Chapter 4: Scheme Description — Summary

Chapter 4 addresses a foundational question for the Examination: what development would the draft DCO actually authorise? BEPS's central objection is that the application does not yet provide a single, complete and legally reliable description of the Scheme. Material parameters are dispersed across the Environmental Statement, Works Plans, Land Plans, Design Principles, outline management plans and draft DCO, while important components remain subject to broad flexibility. The resulting risk is that the development ultimately constructed could differ materially from the development assessed in the Environmental Statement.

Figure 11.6: Likely and Suitable Routes to the Scheme
 Sites 7, 8 and 9
 Revision A

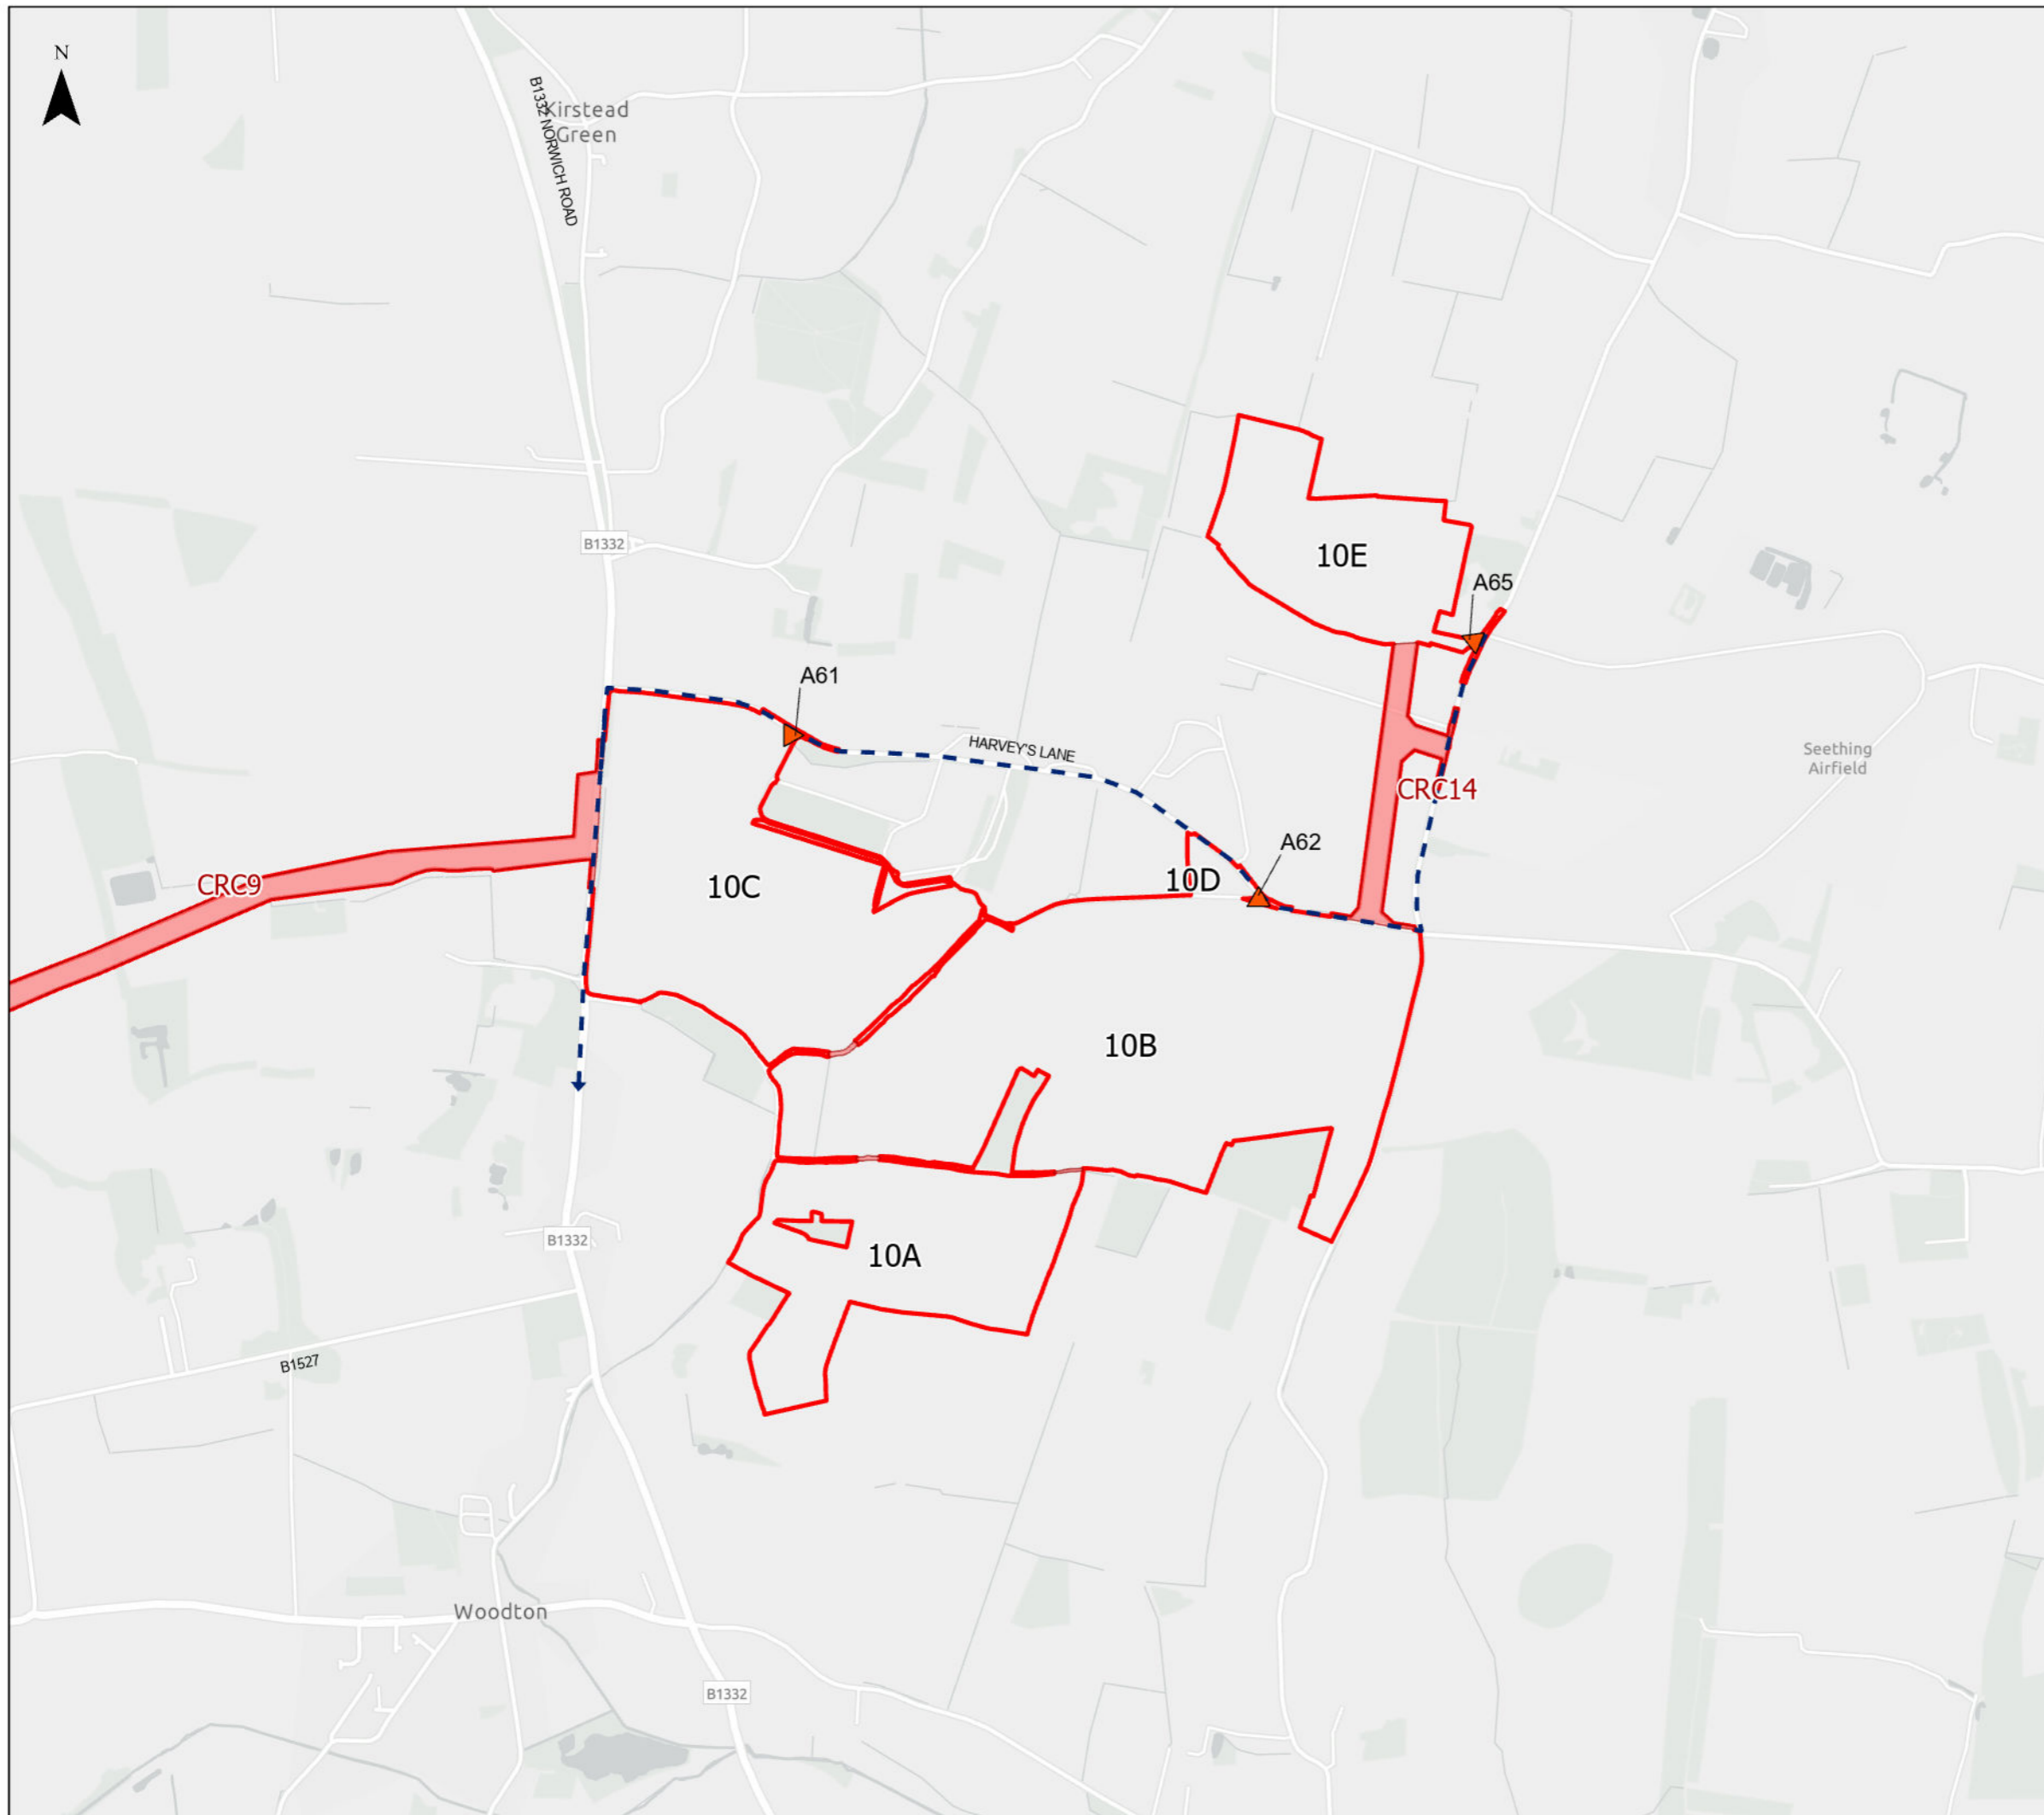
Sites 7–10 present the clearest example. NCC requires Sites 7–9 to be served through CRC8 west of Hempnall and then by internal haul routes to widely separated parcels. The Applicant's submitted strategy instead distributes traffic through The Krons,
